From: Martyn White
Sent: 24 June 2019 12:22
To: Planning.Responses
Cc: Anita Gardner
Subject: AB/48/19/PL & AB/49/19/L

AB/48/19/PL & AB/49/19/L

Listed building consent for internal and external alterations to facilitate the change of use of upper floors to a single, four bedroomed residential unit [use class C3a] and ground floor to a commercial unit (use classes A1,A2 & B1a).

**EXISTING &
PROPOSED SPARKS
YARD LEVEL GROUND
FLOOR PLAN**

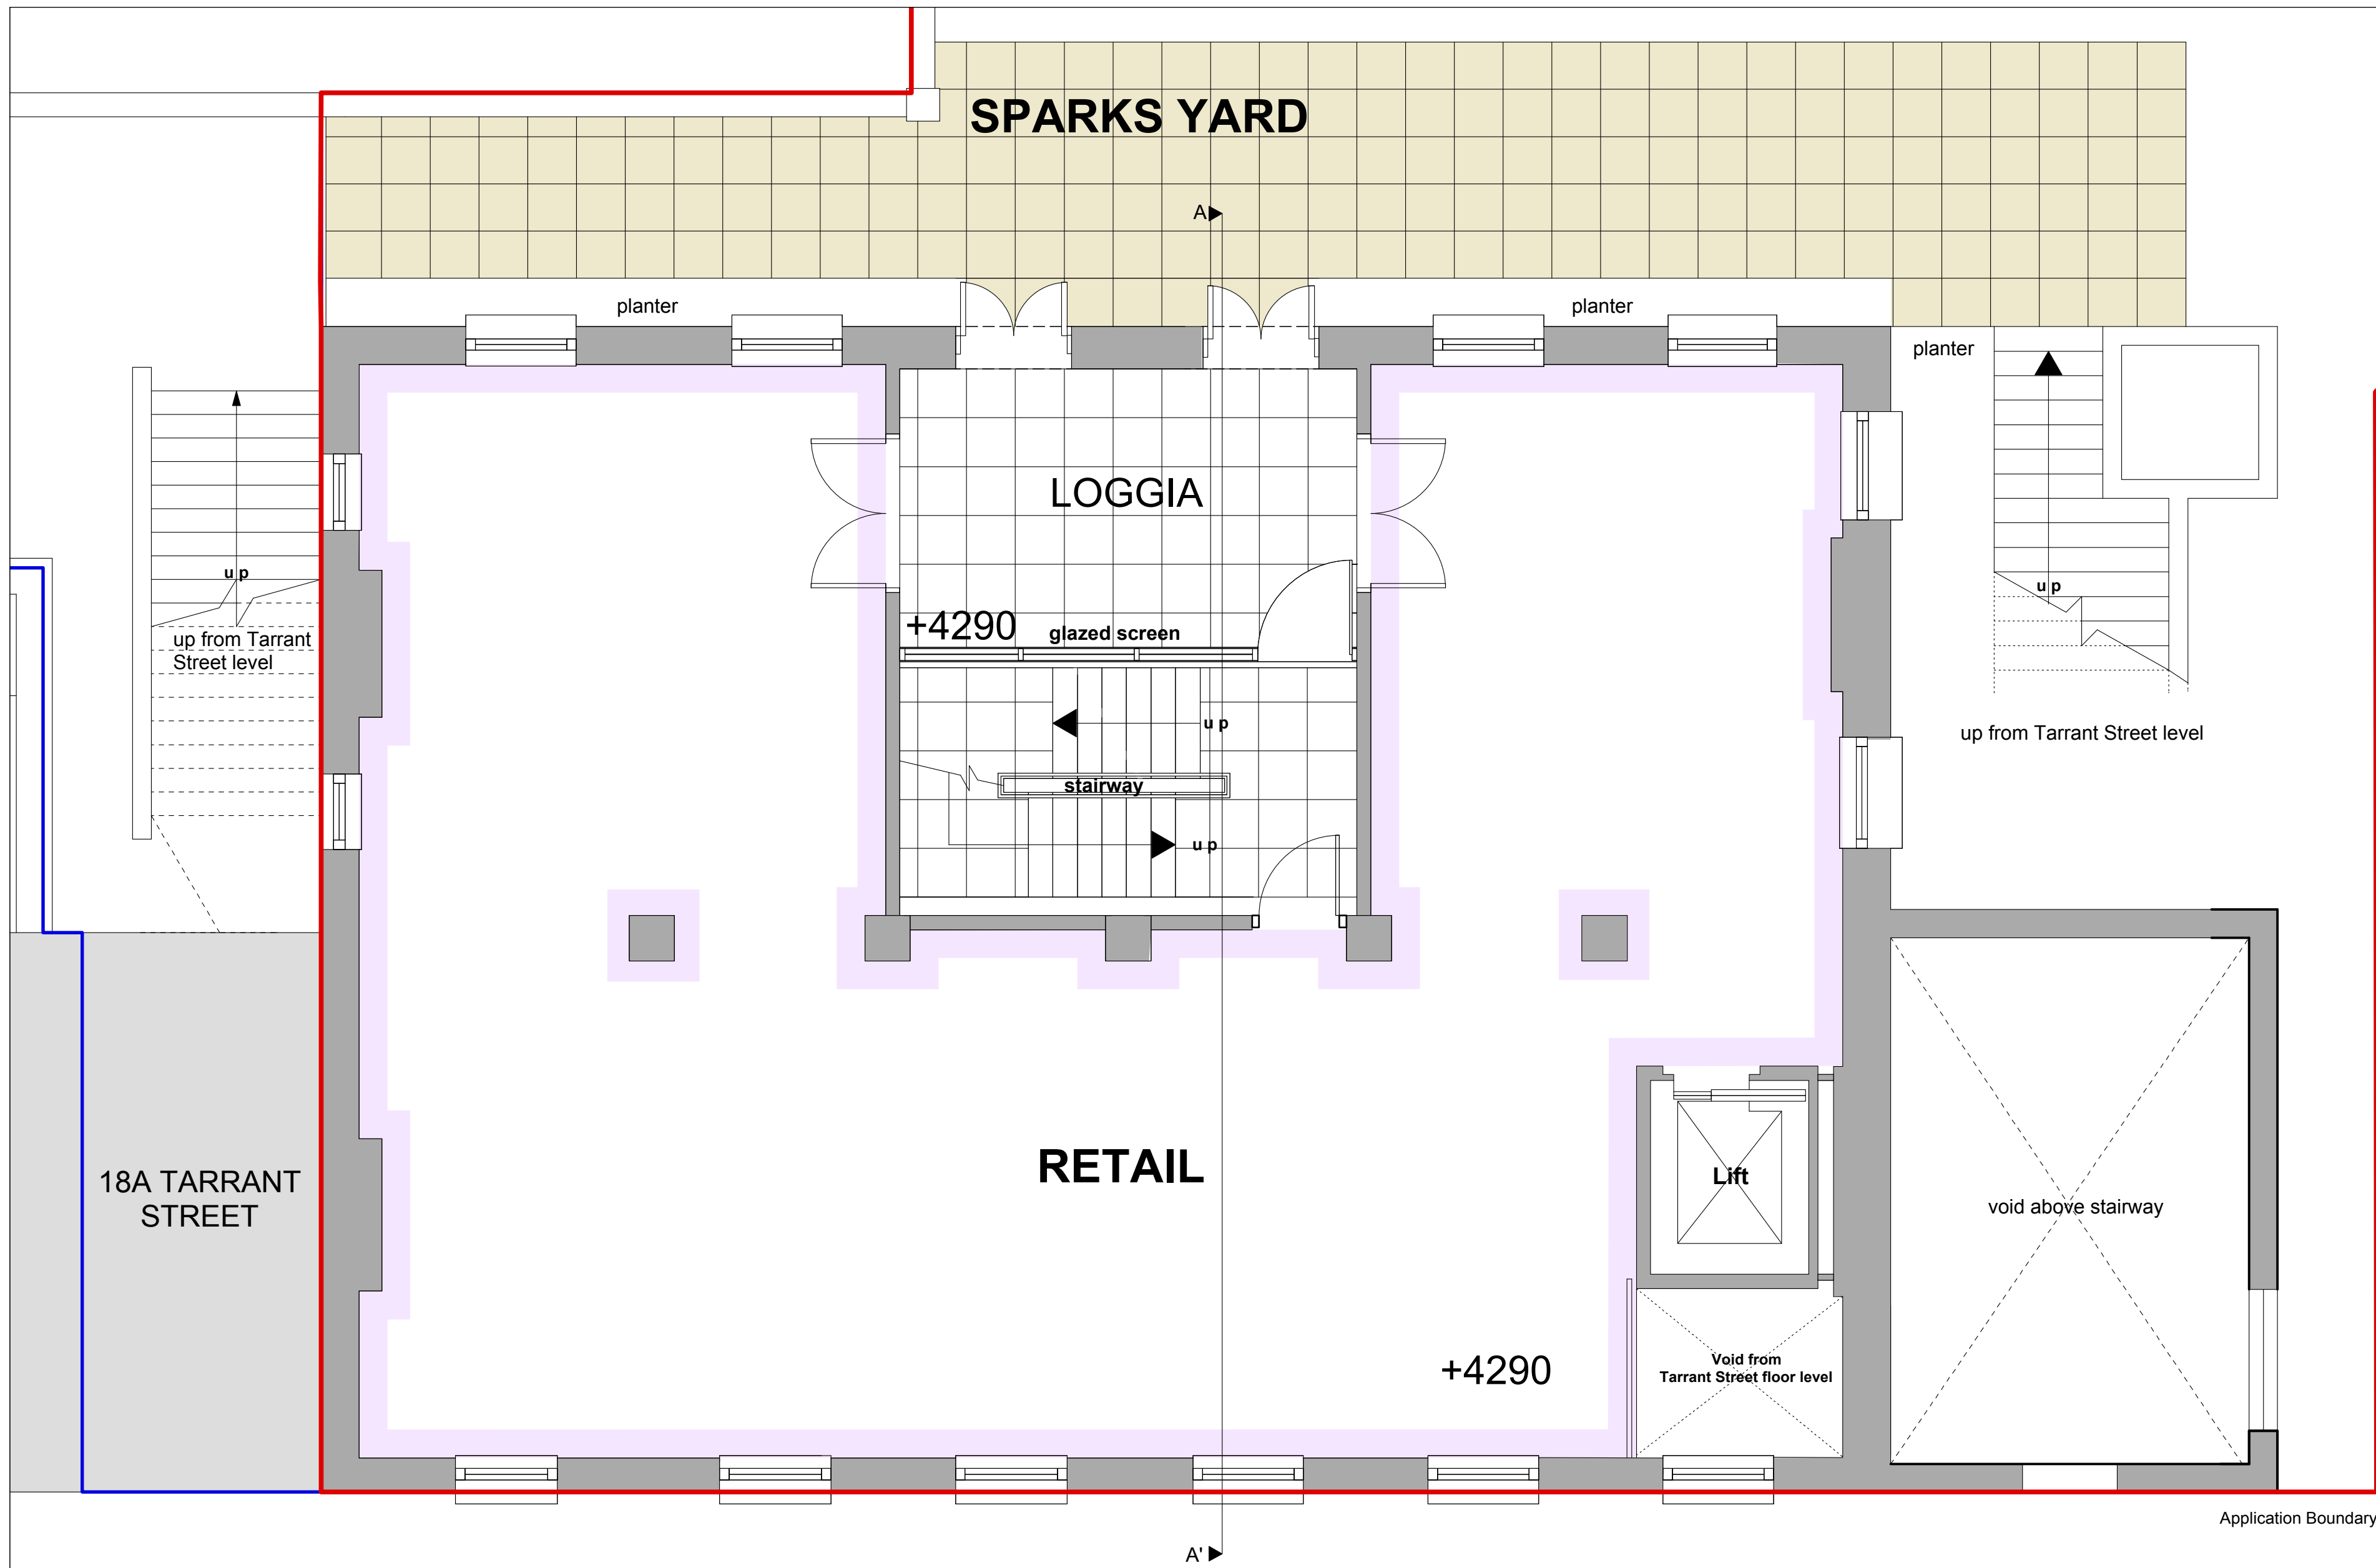
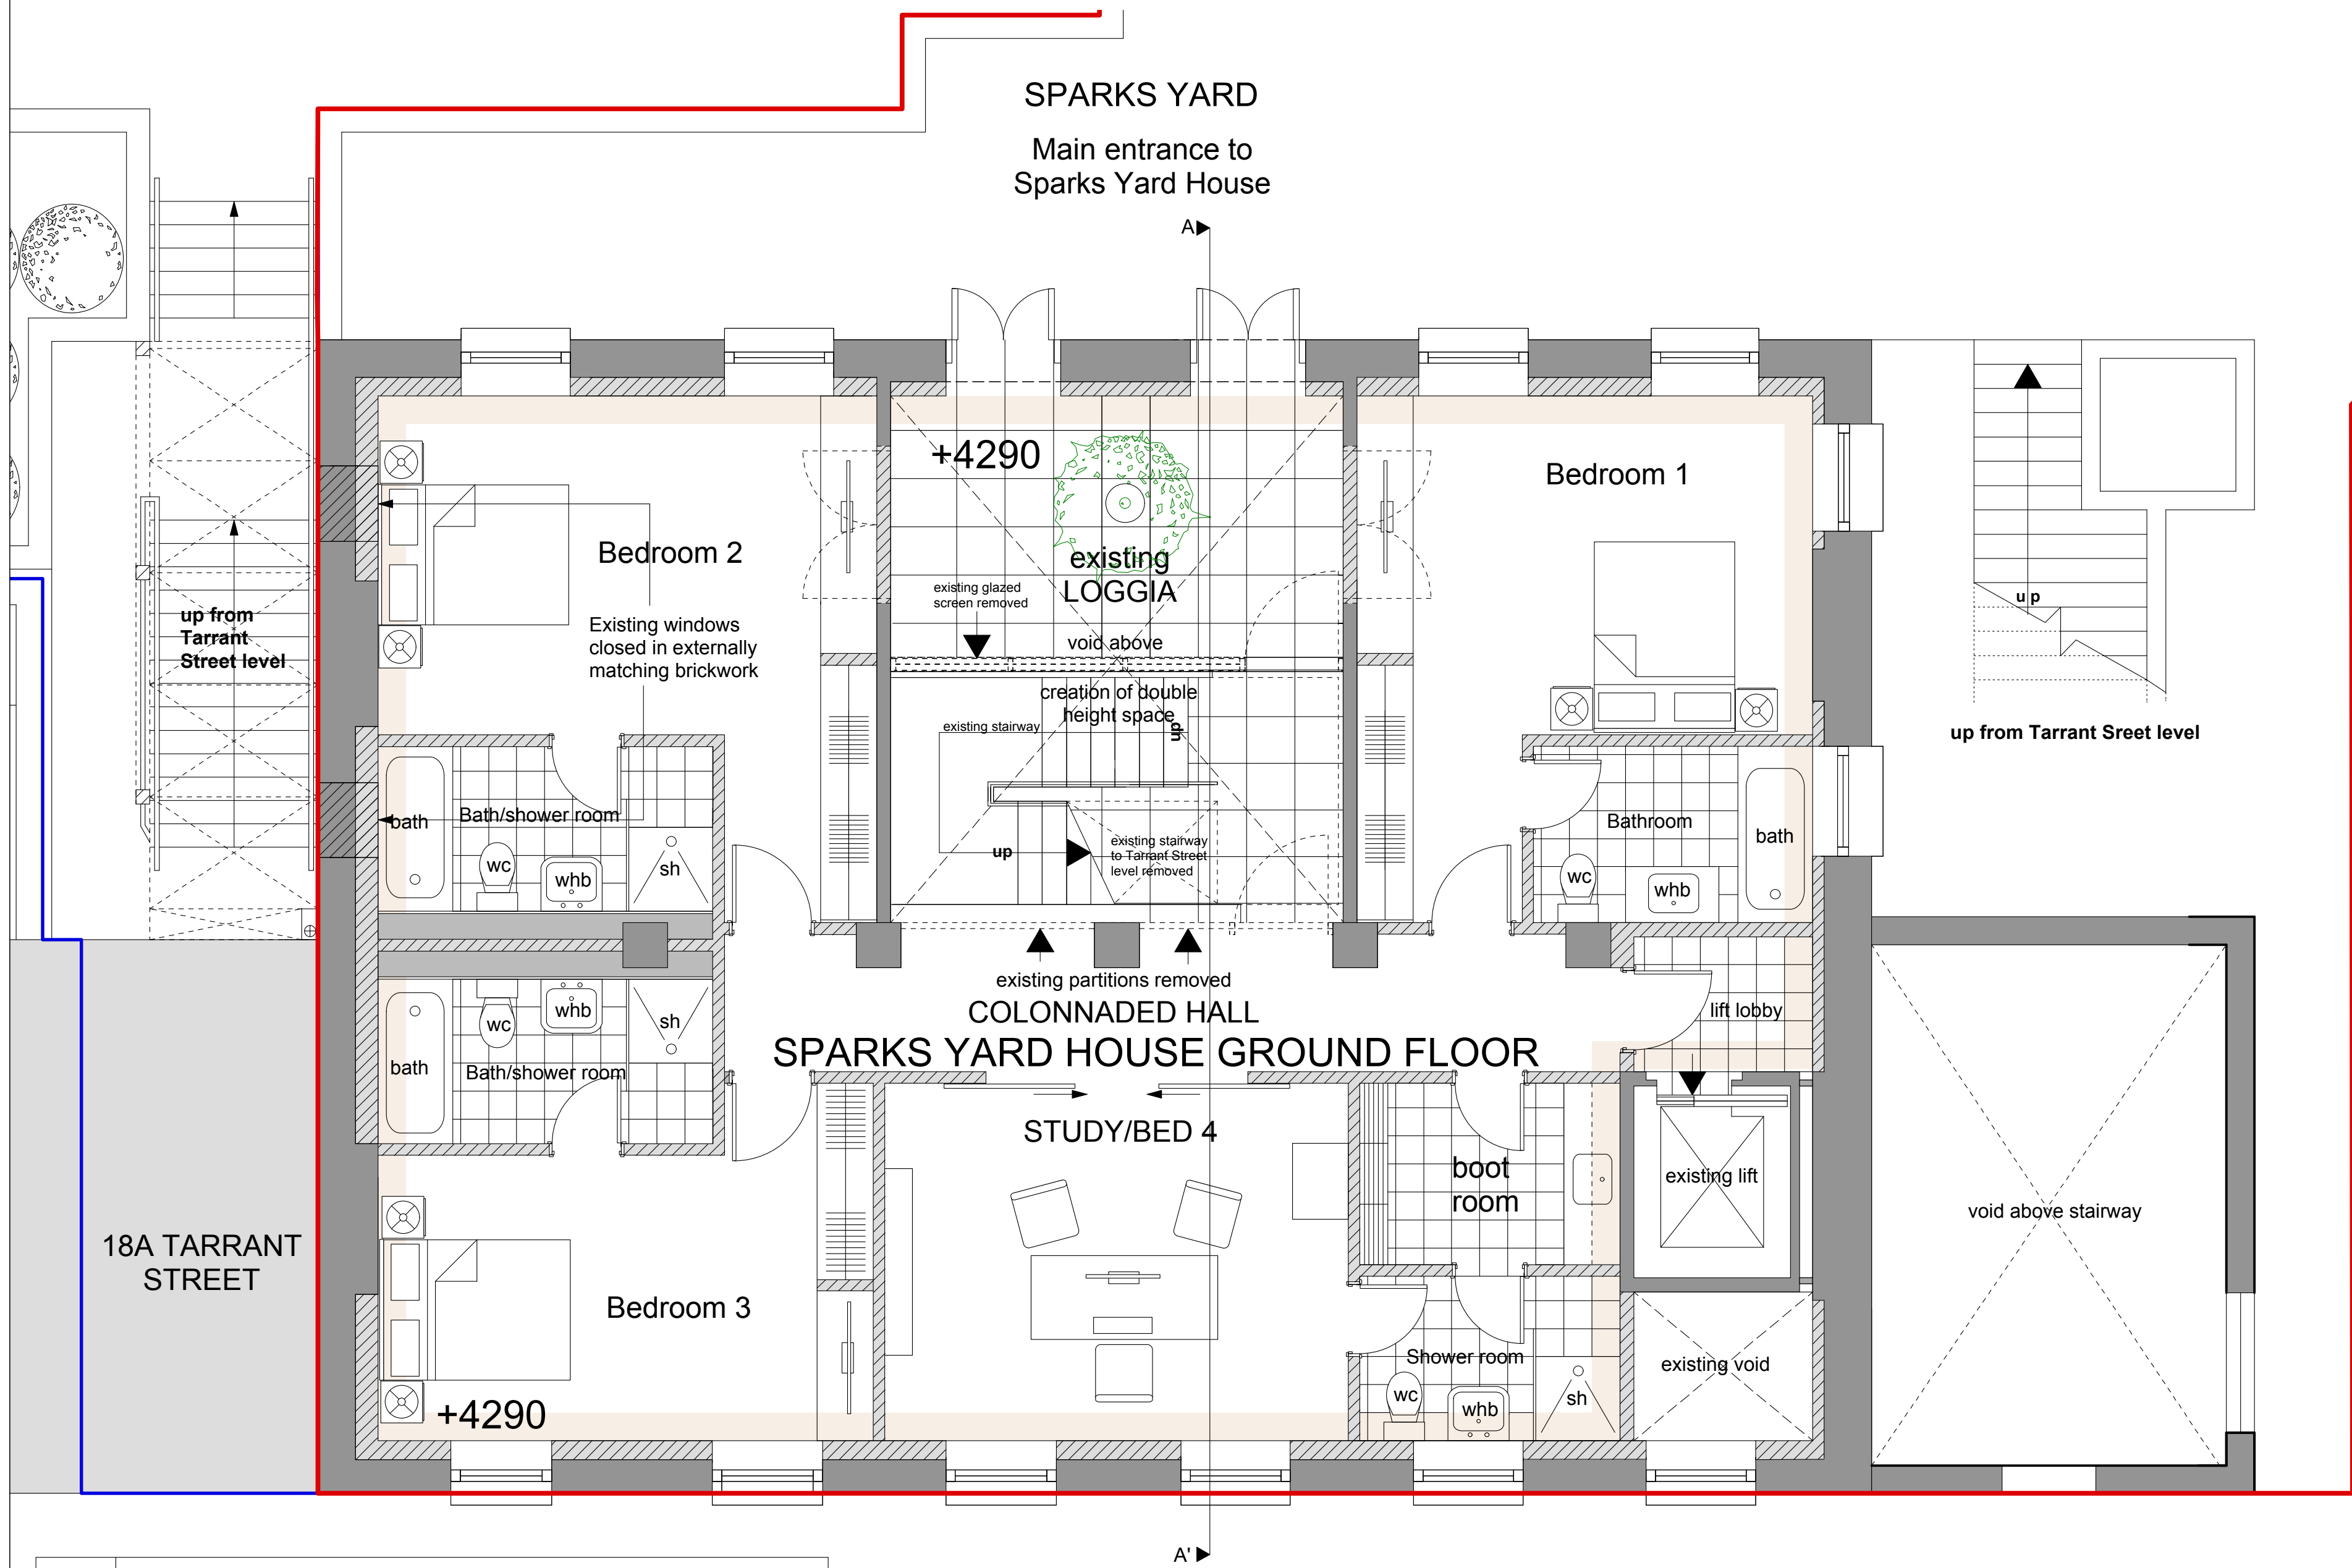
The only concern relates to the proposal to cover internal brick walling with plasterboard. I note that reference is made to the fact that the brick walling will be left exposed if possible. However, covering up a significant amount of the brick work will negatively affect the character of the building. Such an issue should be reconsidered.
